ENVIRONMENT
AGENCY

Date : 17 May 2006

**Flood Risk Assessment - Proposed Mixed Use Development
Land South West of Bicester**

File Ref:SP52SE/12/1

- SITE SURFACE WATER FLOW DIRECTION
- PROPOSED REALIGNMENT OF PINGLE BROOK

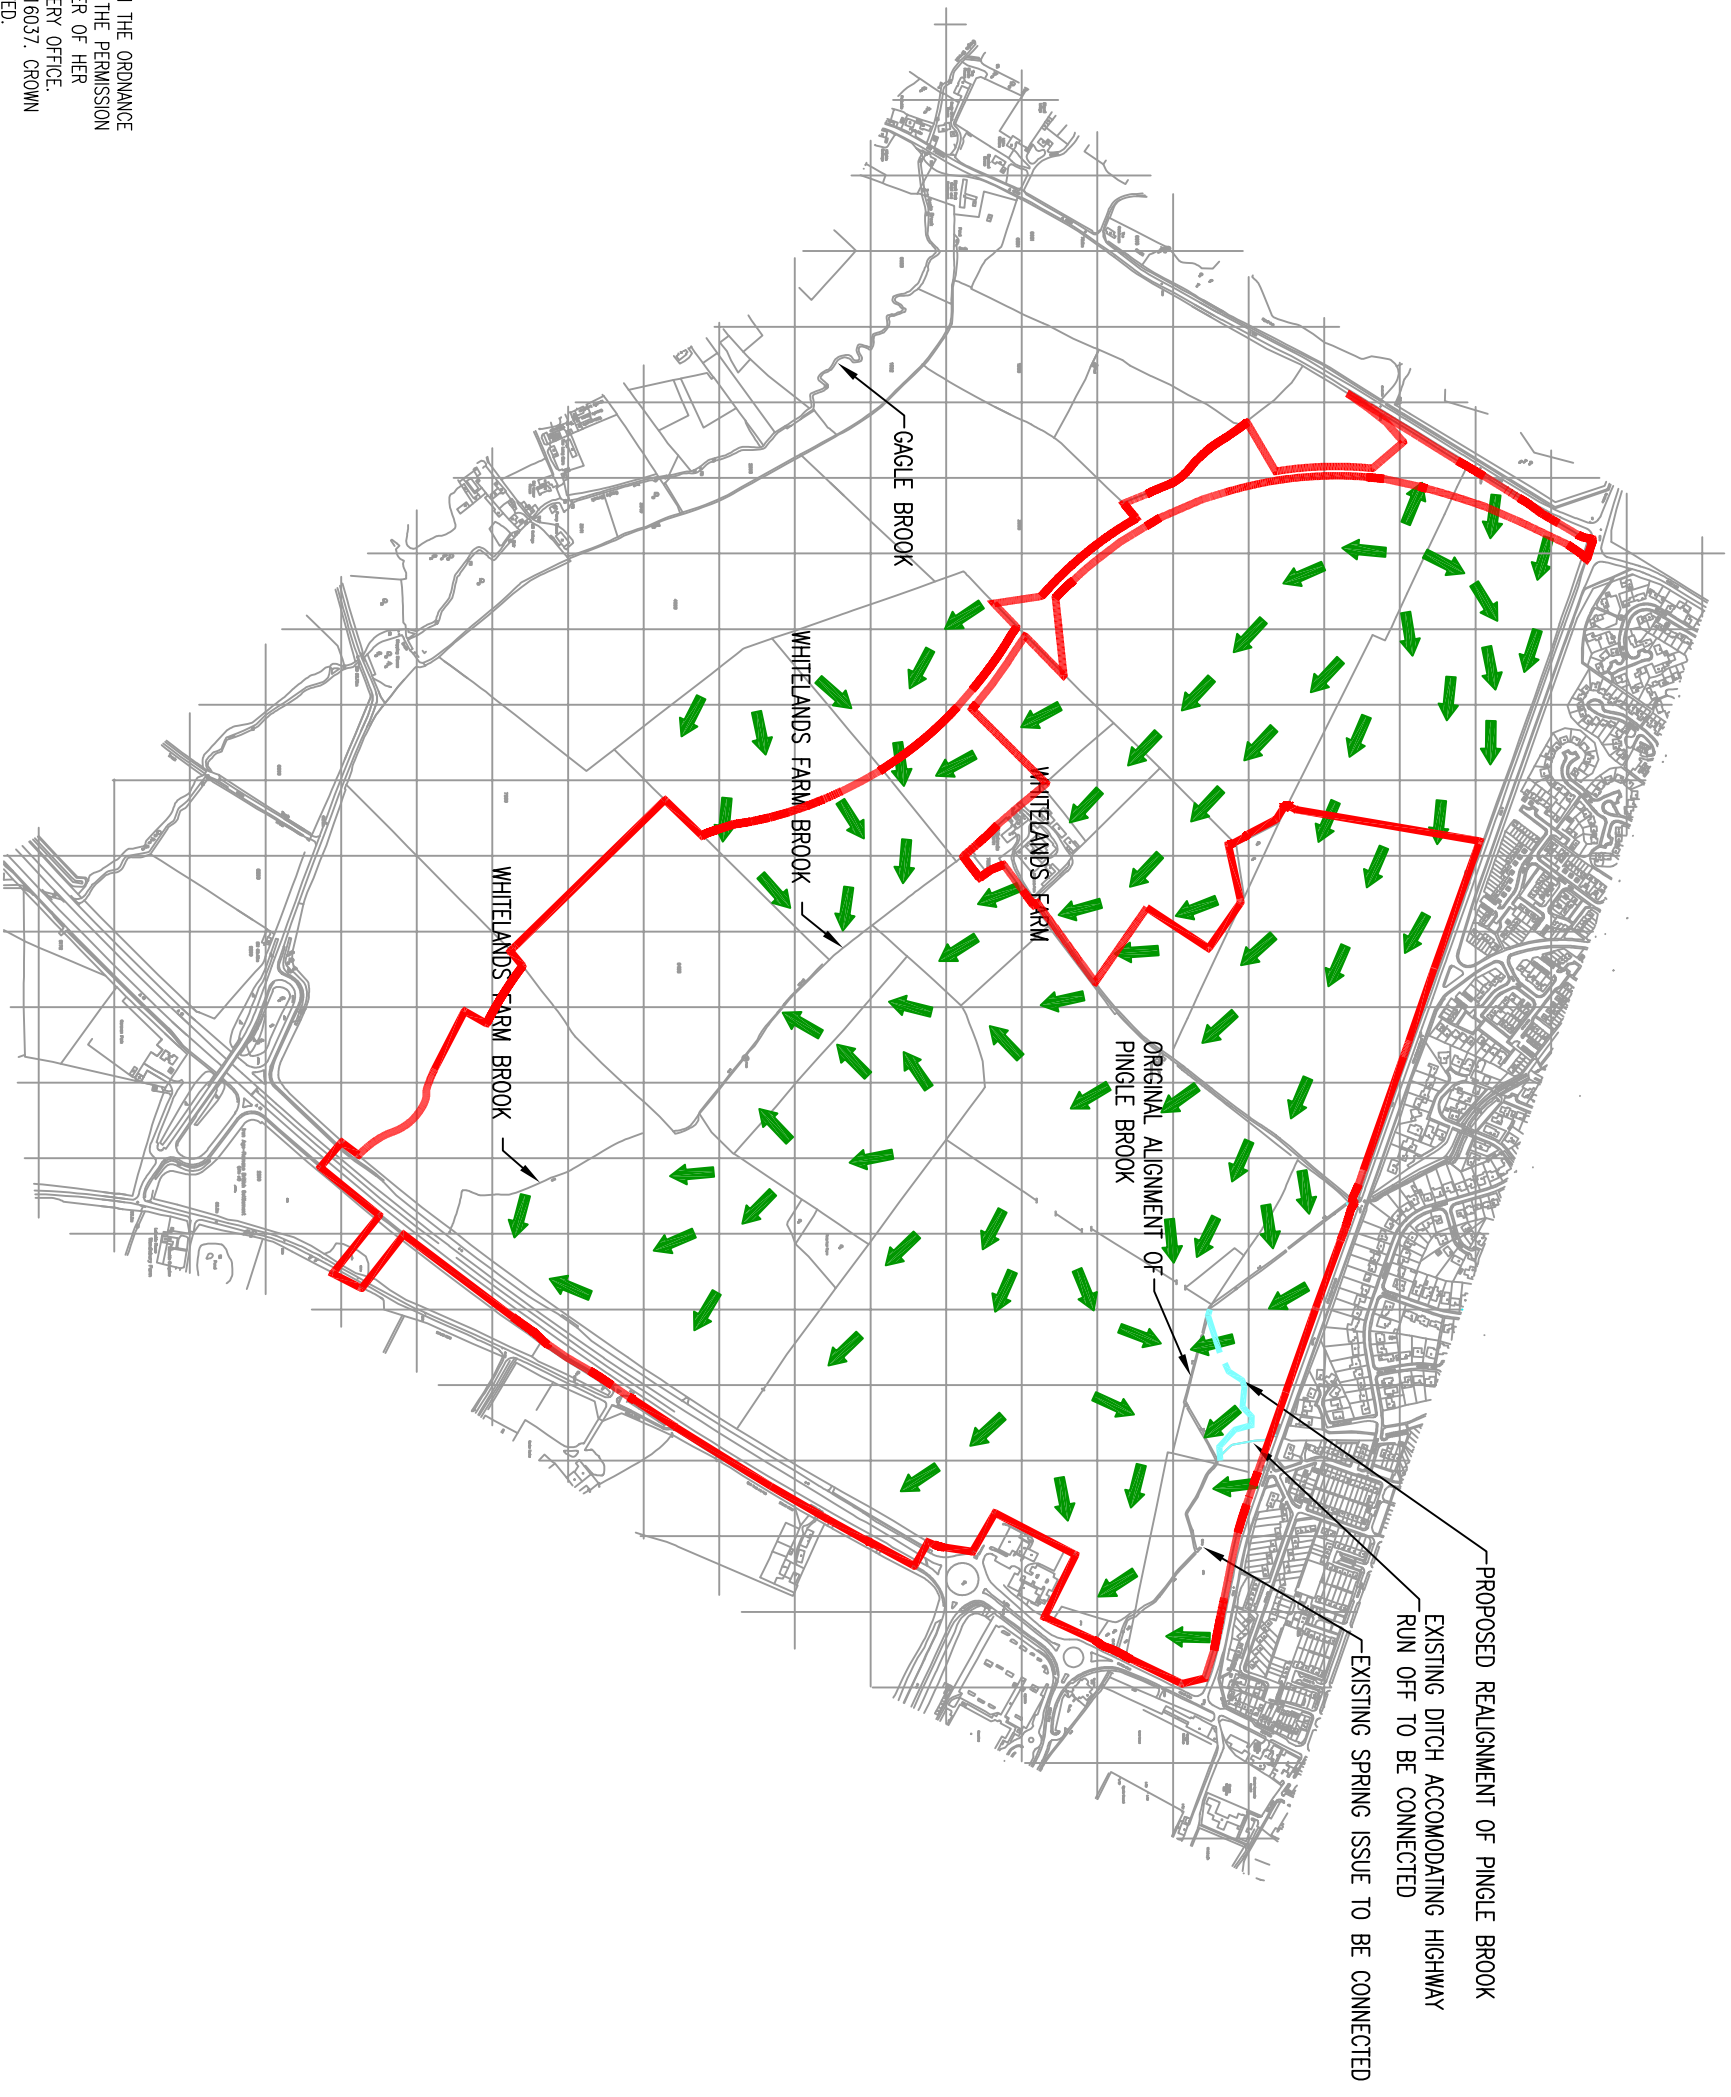
There is also reference to the diversion of a watercourse, it is not clear from the drawings whether this is part of the proposed layout. No details have been provided, or principles establishing the way in which any diversion will be undertaken.

The key on Drawing 1546/FRA/D/002 Rev A is insufficient to allow us to be able to assess the strategy.
